Marge Schmuckal - Re: 65 Monument Street - 2014-02147 - 017-A-005

I am in receipt of your application for a new, replacement deck on the rear of your building. You mentioned 14-433. First of all, I need a full plot plan that shows the new deck on the building with all the setbacks. Second of all 14-433 allows me to grant you only a 5' setback instead of the 3' setback that you are proposing. You must also show me the reason that you can not get the normal setback. It is not an automatic approval.

A1 Plot Plan, revised (CBL: 017 – A-005-001)

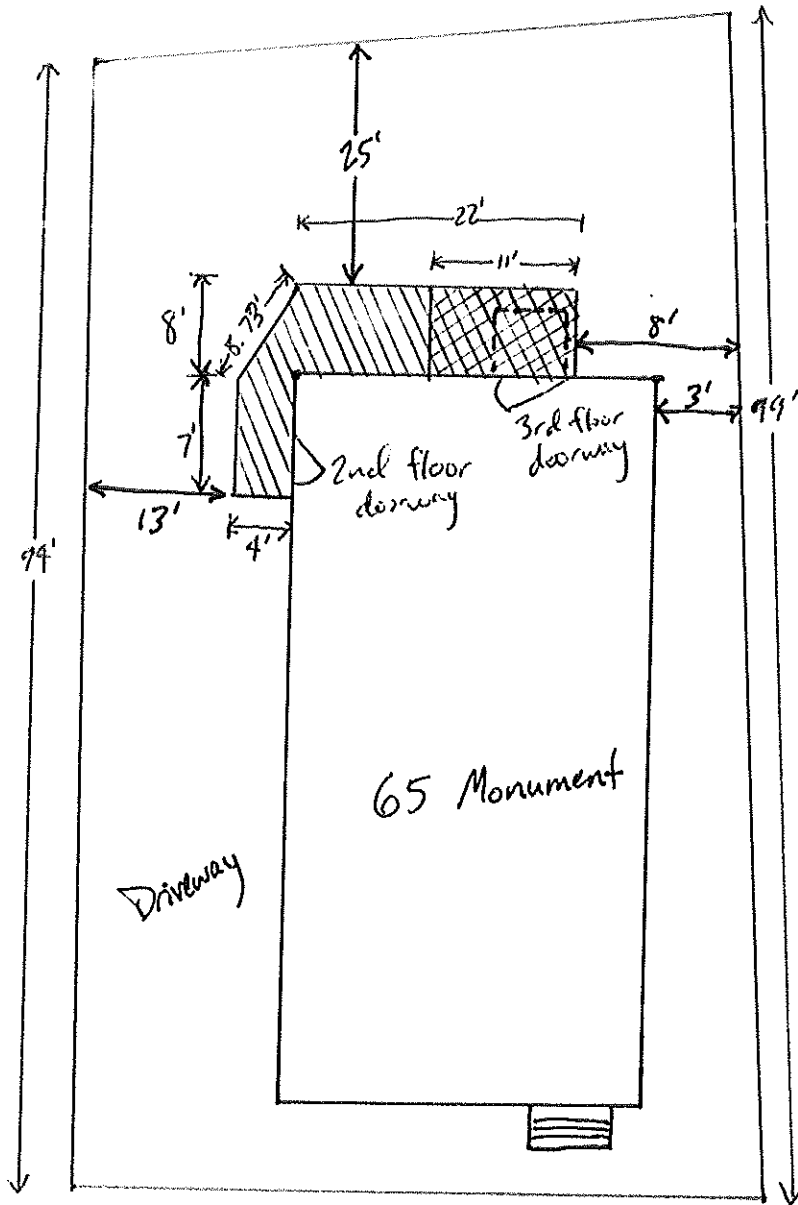
Then that is not what is reflected on your plans. All setbacks are from property lines and not fences. Please be clearer on your plans as to what the measurement is to the side & rear property lines, and explain about the 10' setback and the fence situation. I will wait for your revisions.

I have to put this permit on hold while I wait for a better plot plan showing the new deck and all the setbacks (side & rear). We may have to meet to go over what you are proposing. If you have any questions, please call at 874-8695.

I hope you will find this revised plot plan to be more clear. For an explanation of the setback request, this is what I had included in the G1 65 Monument Deck Application document (2nd paragraph):

I am requesting a setback exception of 2 feet against policy 14-433 to allow the deck to avoid both the window area on the third floor and the exterior basement entrance. Attachment A3 Floor Plan shows the floor plan from our home inspection. The third floor (far right) has limited room in the rear of the home to access a deck. A 5' wide window currently exists in the rear kitchen wall that will be converted to a sliding glass door, as this is the only viable option for rear egress. Attachment A4 Price Structural Engineering Plan (S-1) shows the positioning of the column just past the basement entrance.

I can create a new plot plan that merges that A1 and A2 drawings, but I am not requesting a 3' setback. I am requesting a 2' exception for a 8' setback. I need the extra 2' so that I will not block the basement entrance and so that I can go around the window on the 3rd floor, which is my only opening for the deck access. The house is currently only 3' from the neighboring fence, which is contributing to the difficulty of a full 10' setback.
